CITY OF ALBUQUERQUE

RE: Presbyterian Hospital SE Parking Garage

Grading and Drainage Plan Stamp Date: 12/23/19

Hydrology File: K15D005G

PROPOSED DRAINAGE MANAGEMENT PLAN

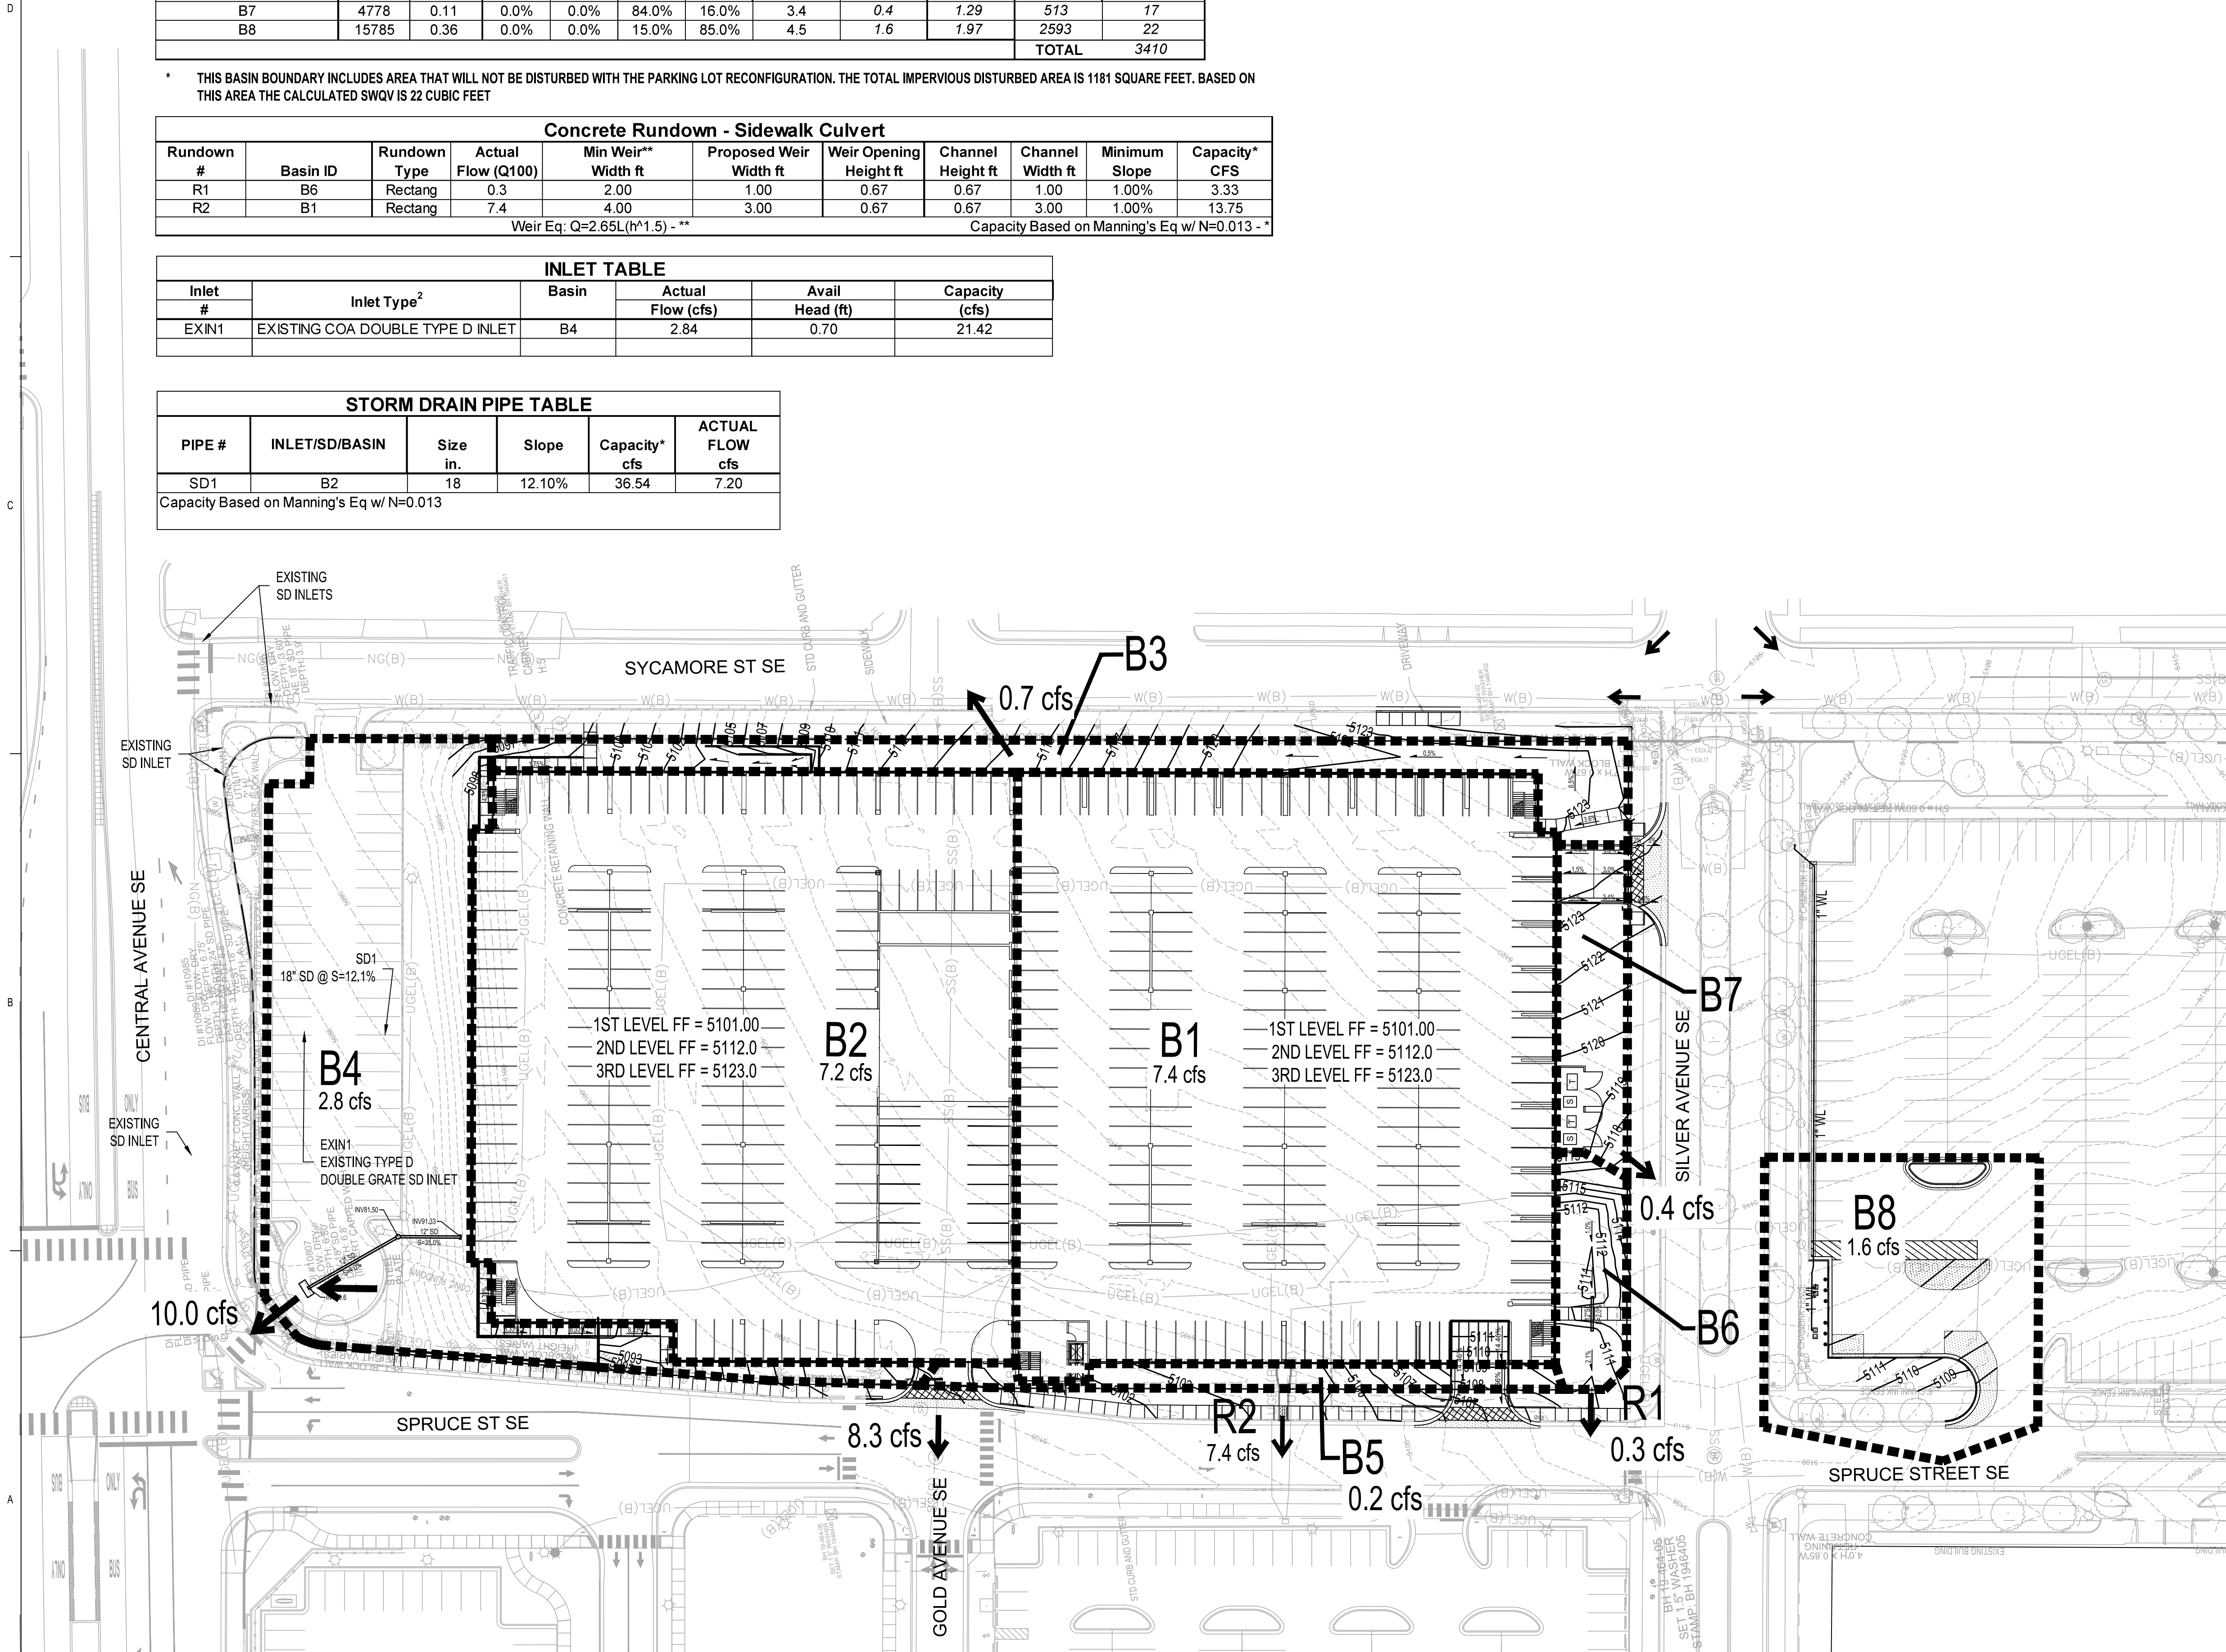
1. The plan must state that: you could provide onsite management, you do not want to (due to cost or convenience), and the owner is electing to make the Payment in Lieu of onsite management.

2. Payment in Lieu (Amount = 3388cf x \$8/cf = \$27,104) of onsite management of the stormwater quality volume (SWQV) must be made. Provide SWQV calculations.

GRADING & DRAINAGE PLAN

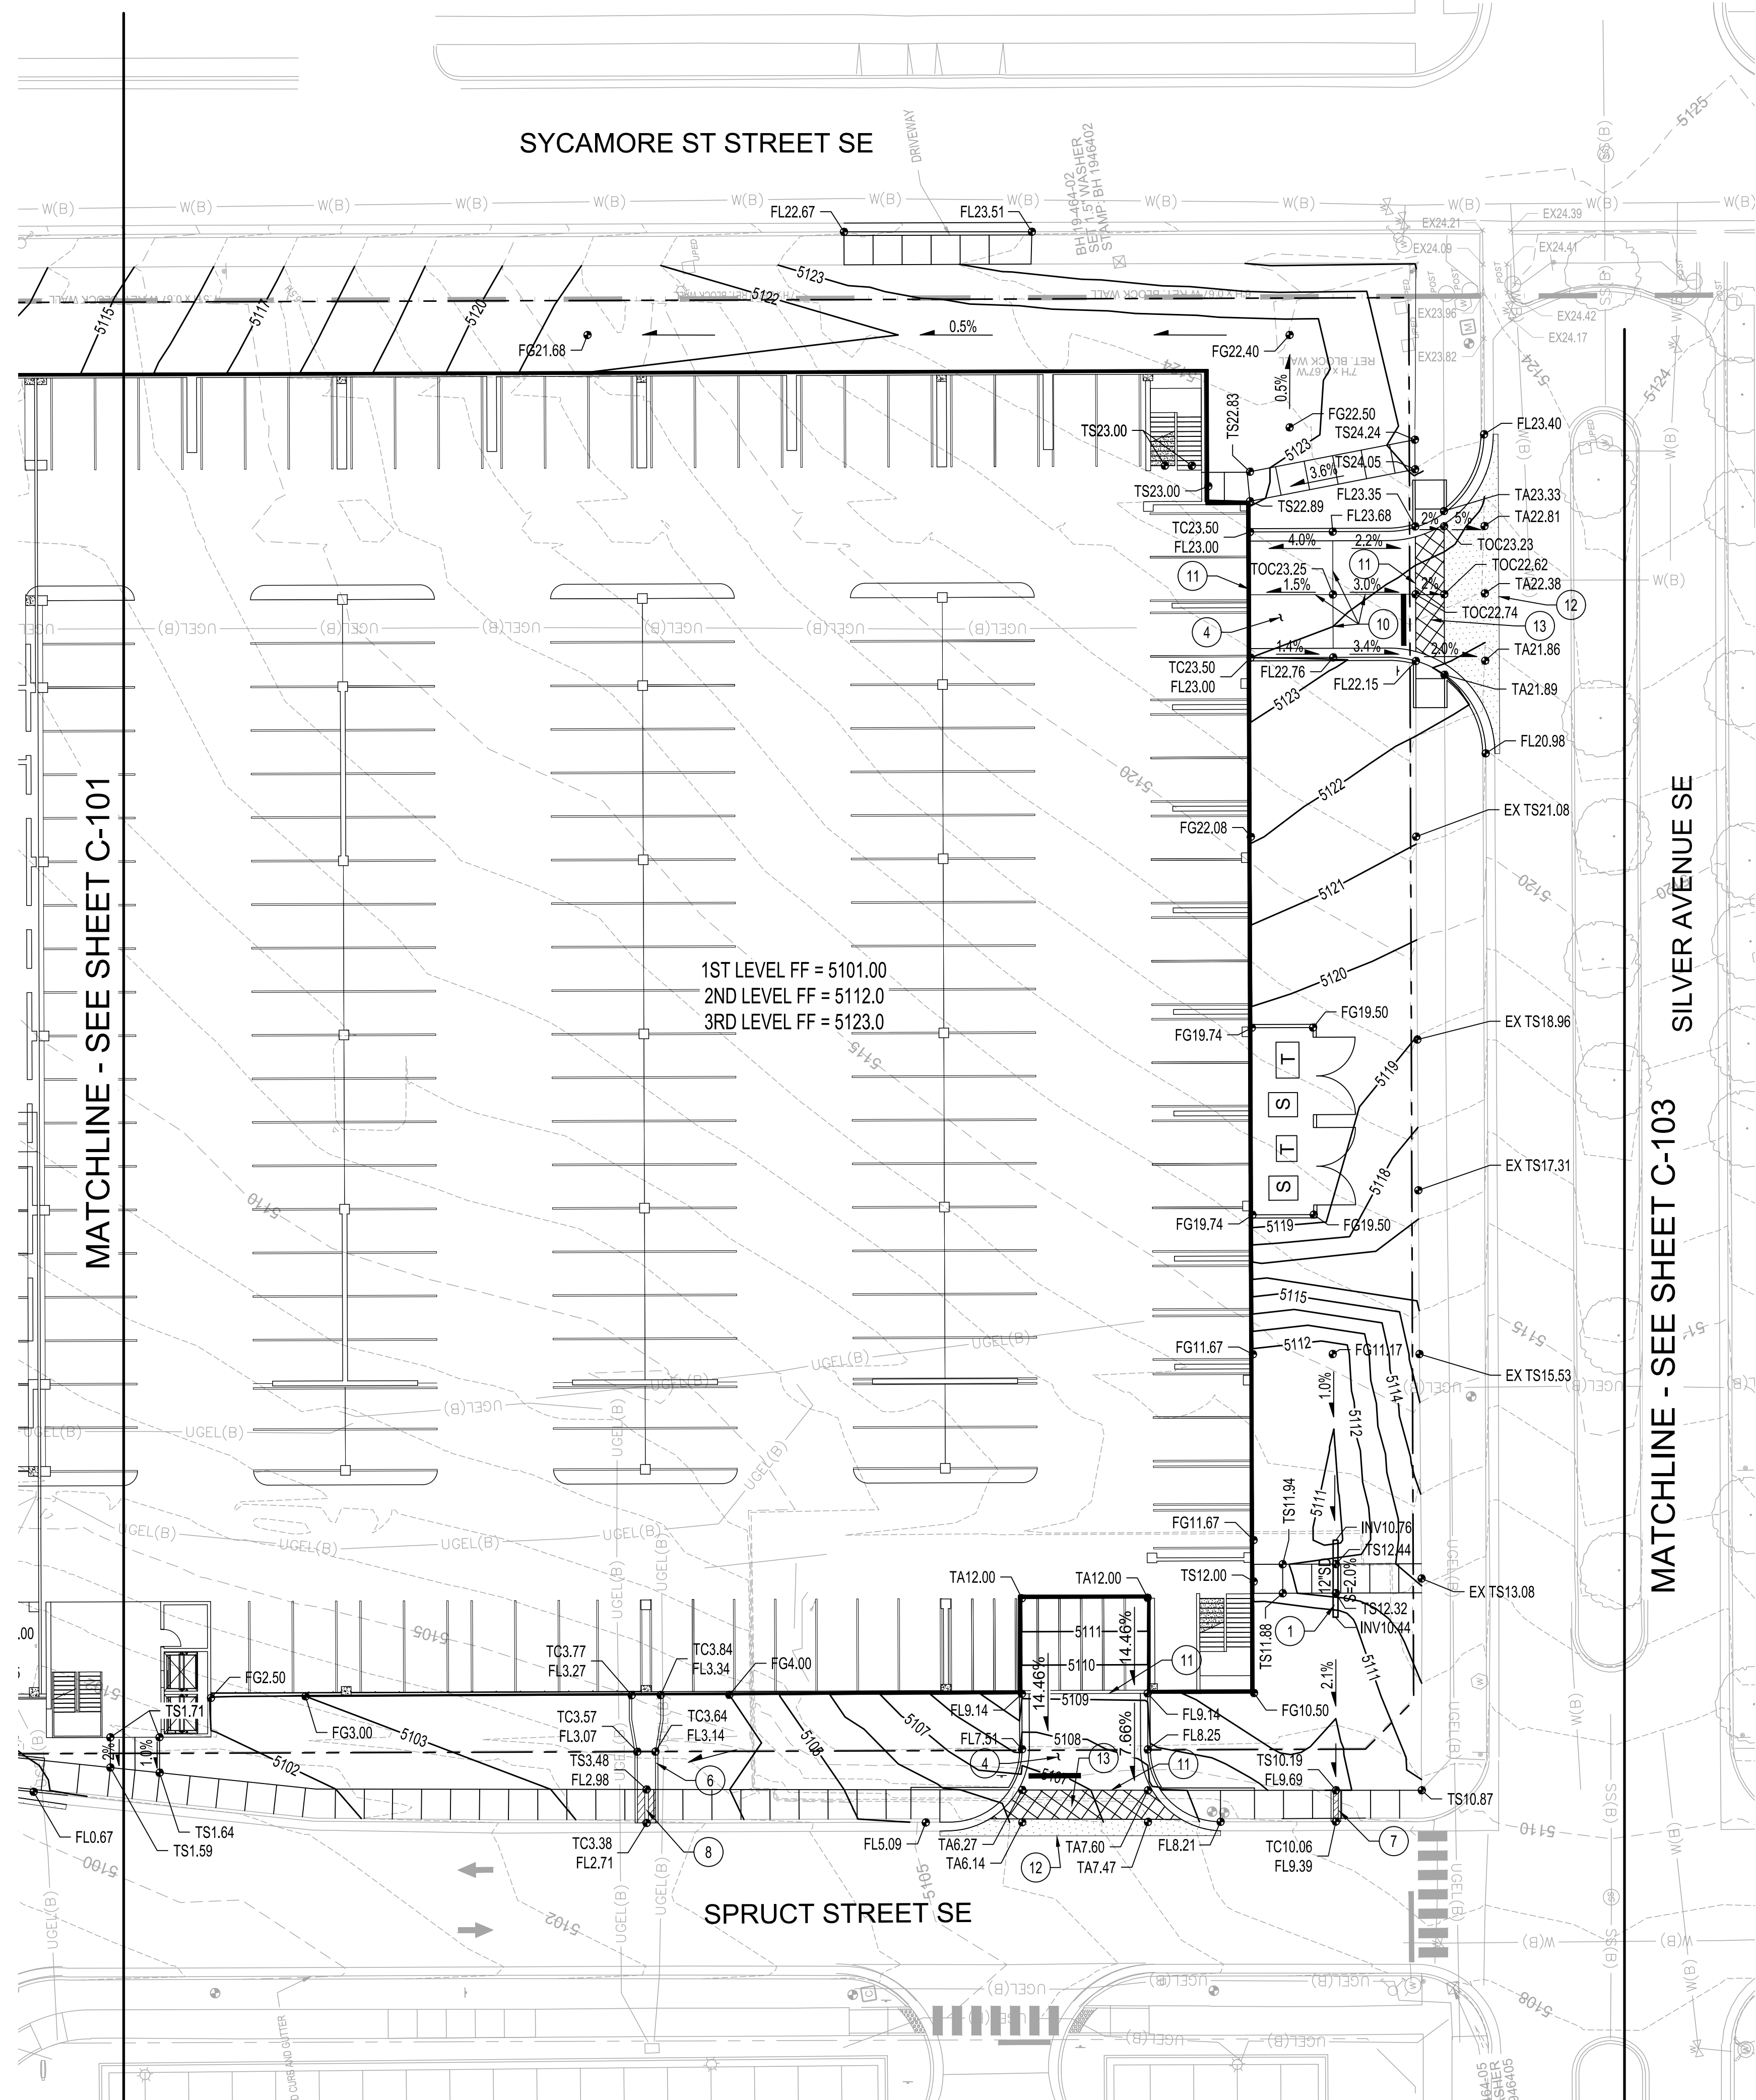
- 3. Flow depth (and EGL) on Silver, in front of the garage entrance, needs to be calculated. Demonstrate that the EGL is less than the proposed waterblock height. Otherwise a standard 0.87' waterblock is required.
- 4. As a reminder, if the project total area of disturbance (including the staging area and any work within the adjacent Right-of-Way) is 1 acre or more, then an Erosion and Sediment Control (ESC) Plan and Owner's certified Notice of Intent (NOI) is required to be submitted to the Stormwater Quality Engineer (Doug Hughes, PE, jhughes@cabq.gov, 924-3420) 14 days prior to any earth disturbance.
